Department of Environmental Health

Mi Cancun
115 South Raleigh St.
Angier, NC 27501

The application, plans and specifications for the above referenced facility were reviewed and cannot be approved at this time. Enclosed you will find the application. Provide information for the highlighted items and resubmit the completed application to our office.

1 FLOOR PLAN
 SCALE: 1/4" = 1'-0"

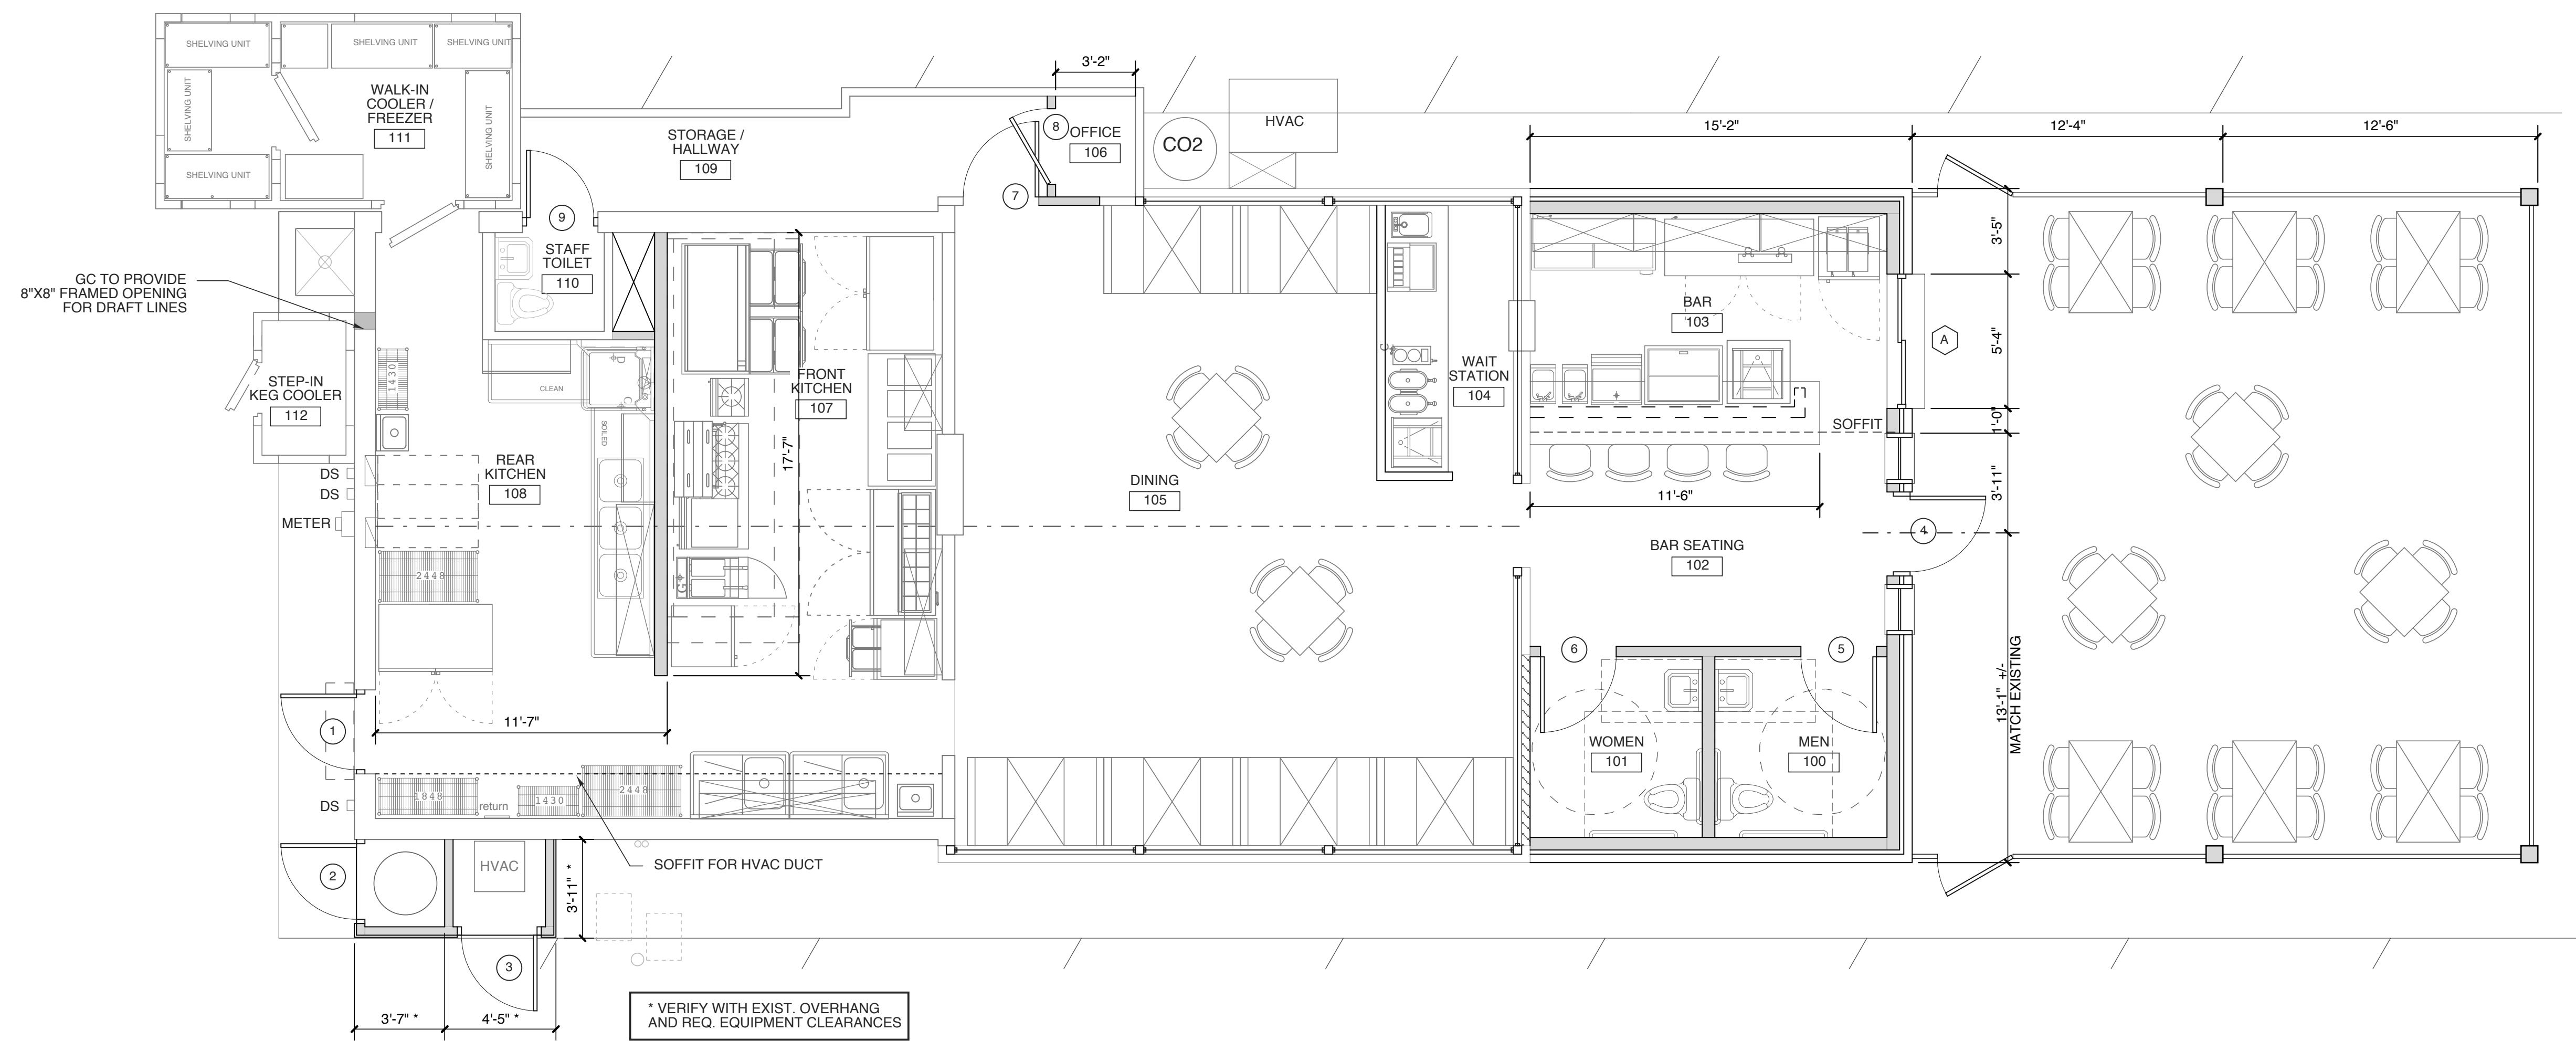
The proposed plan increases seating/dining space significantly without proportionately increasing the kitchen size. The existing facility did not adequately support the dining area and menu. The facility had permit conditions limiting food processes due to limited refrigeration, dishwashing area and storage. While there are positive changes in respect to the proposed kitchen plan, changes are needed in order to adequately address dry storage, dishwashing, air-drying and utensil storage.

In addition, the extensive menu and processes require additional prep space, such as prep tables. The size of the walk-in cooler/freezer combo must be larger to accommodate the refrigerated produce, raw meat species, thawing, prepared food and multiple types of salsas. The bar area shall provide a three compartment sink for the washing of glassware. No soiled raceway is identified. Specify where soiled utensils are staged in kitchen. Specify where bulk hot foods are held prior to placing in hot wells. Per a conversation with the Fire Marshal, the hallway cannot be used for storage. Specify on plans where large chip containers and bulk dry goods, such as large bags of beans, rice, etc. are stored. Specify if liquor is served and storage location. Provide spec sheets for wall mount shelving in bar and cabinetry. Please resubmit revised plans to Harnett County Central Permitting. The completed application shall be resubmitted to Harnett County Environmental Health.
